Public Authority Response

The City has reviewed the proposed modifications to the basement design and layout and internal changes to the layout of the ground floor. The proposed modifications are considered to have no further adverse civil or flooding environmental impacts and there are no objections raised to the proposed parking modifications or changes relating to subdivision.

FLOOR PLAN BASEMENT

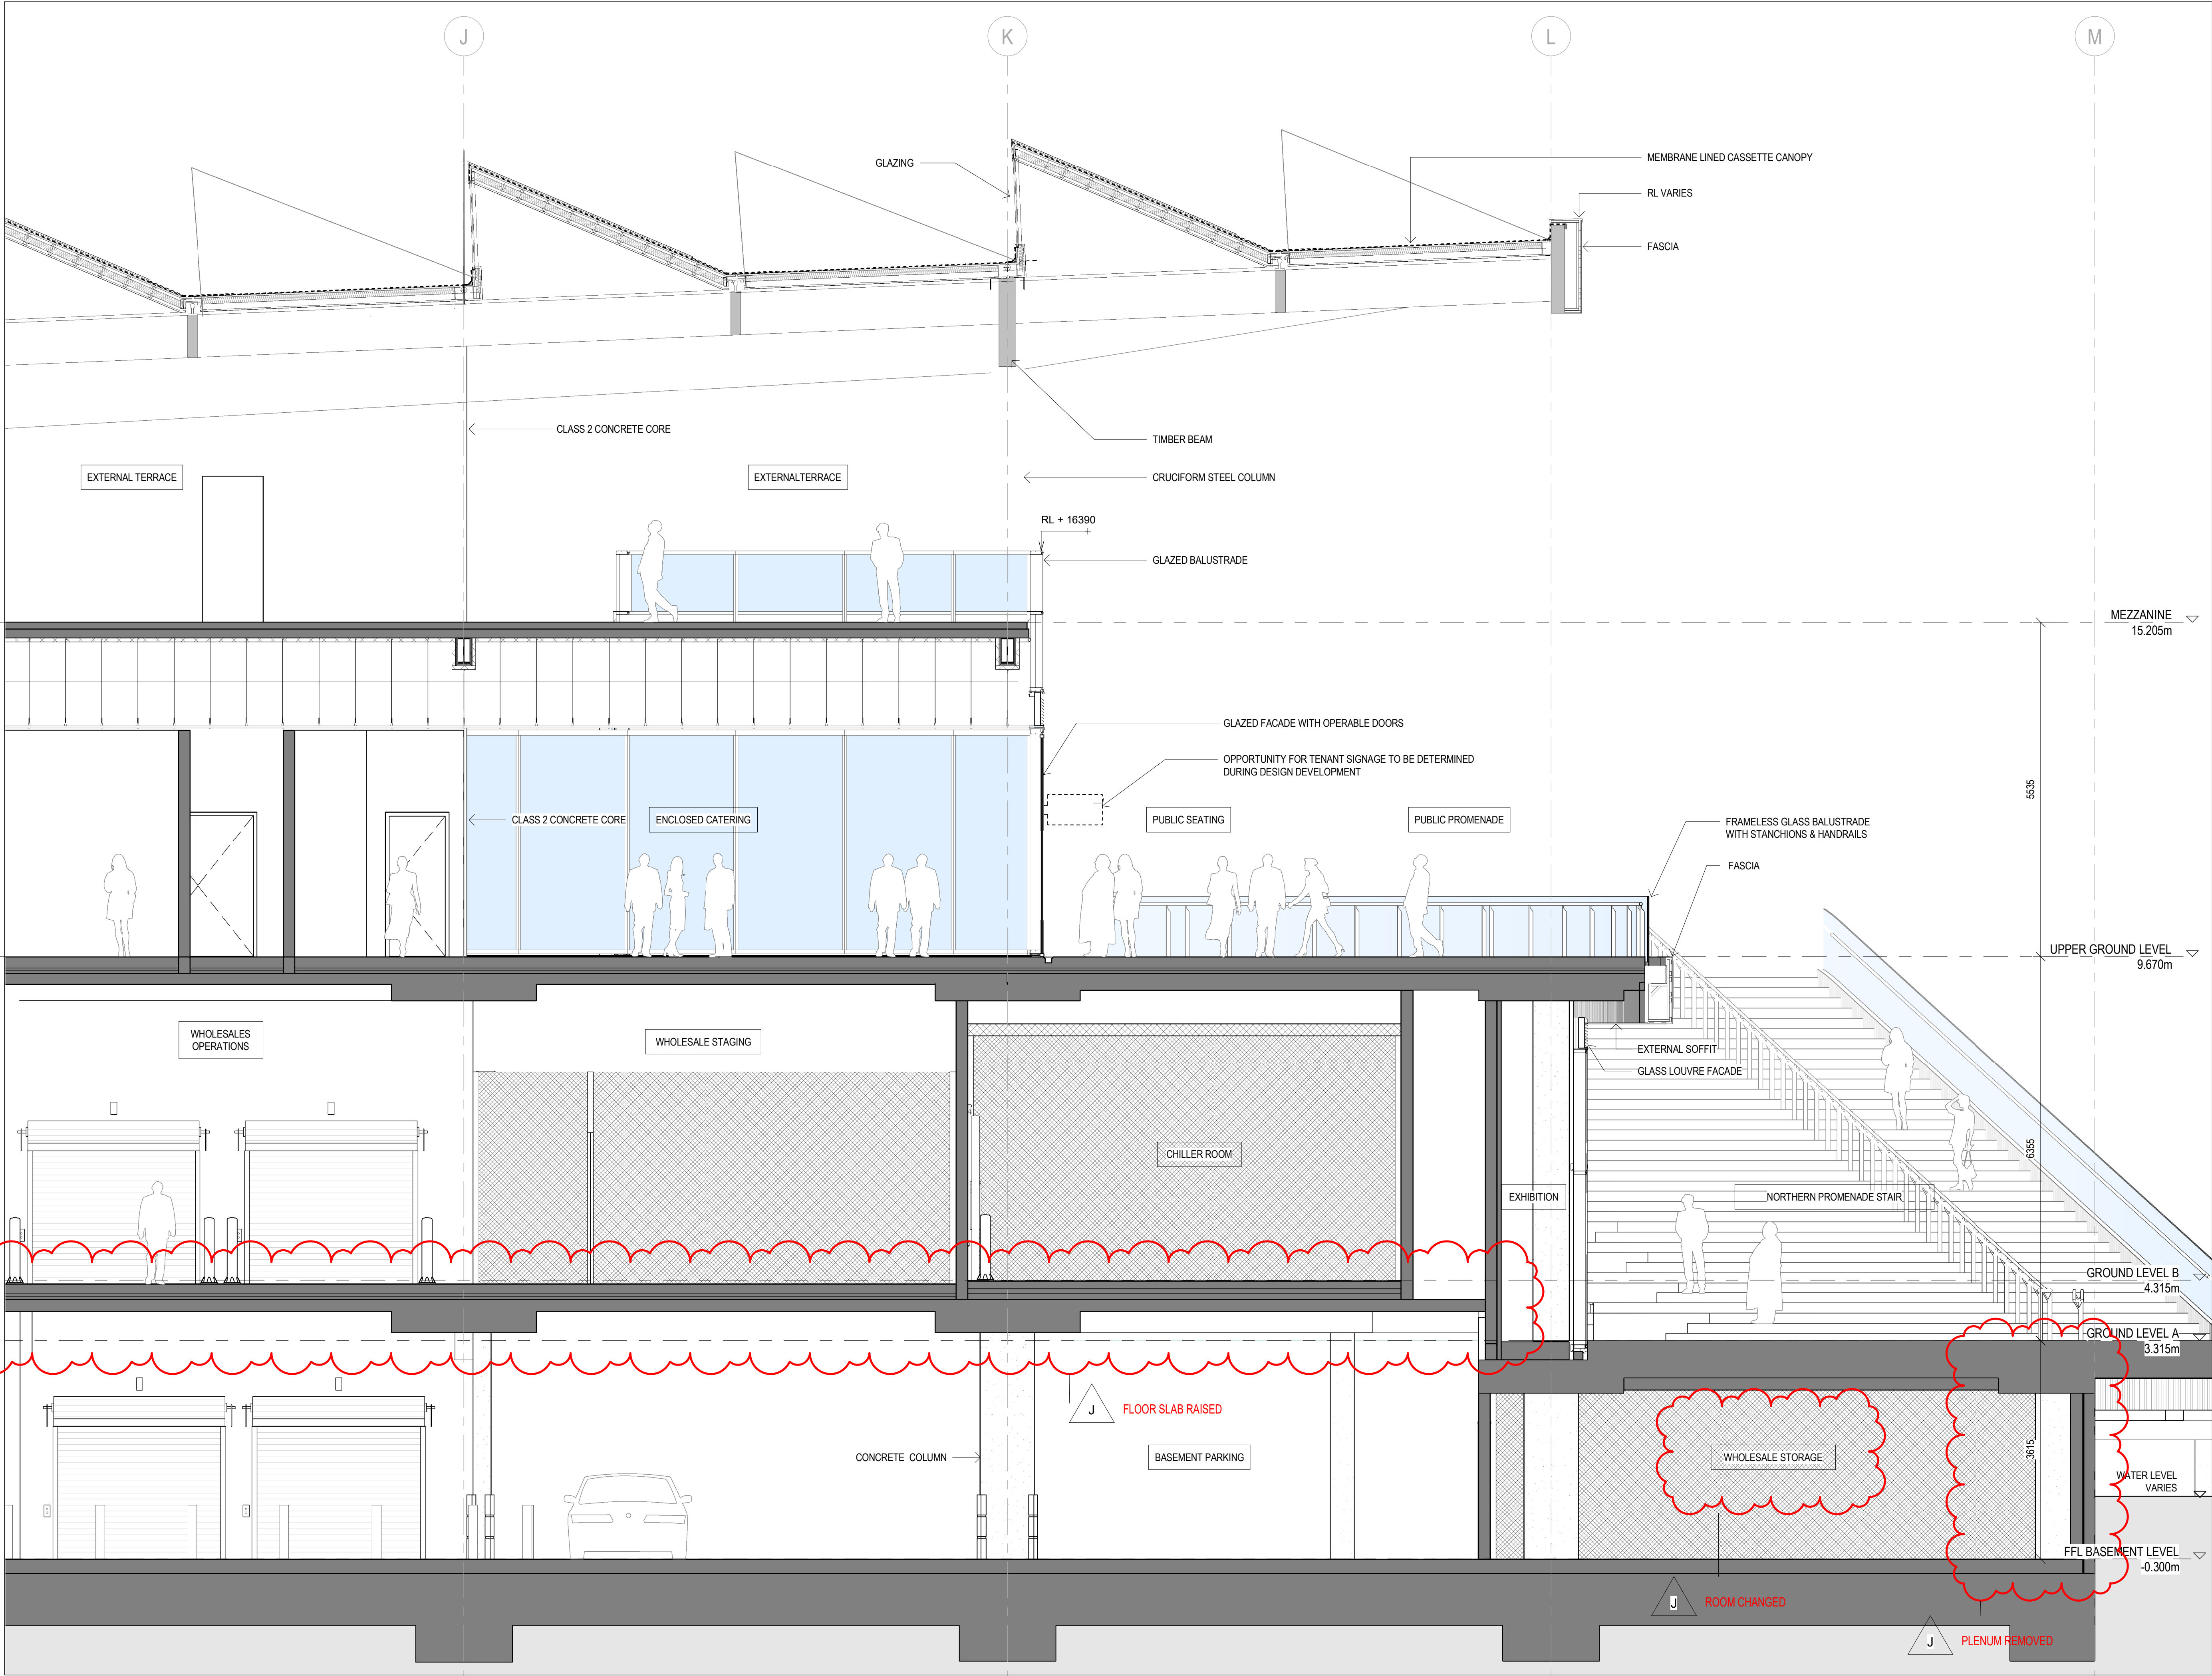
As the modification will result in an increase of small car parking spaces, it is recommended that the design and layout of all off-street small car parking spaces must comply with the minimum requirements of Australian Standard AS/NZS 2890.1 - 2004 Parking facilities Part 1: Off-street car parking and Council's Development Control Plan relating to parking and dimensions. The details of the carpark layout and dimensions must be submitted to and approved by the Principal Certifying Authority prior to a Construction Certificate being issued. Further, all small car spaces must be clearly marked and identifiable as small car spaces. The signs or line markings must be in place and approved by the Principal Certifying Authority prior to an Occupation Certificate being issued and must be maintained in good order at all times.
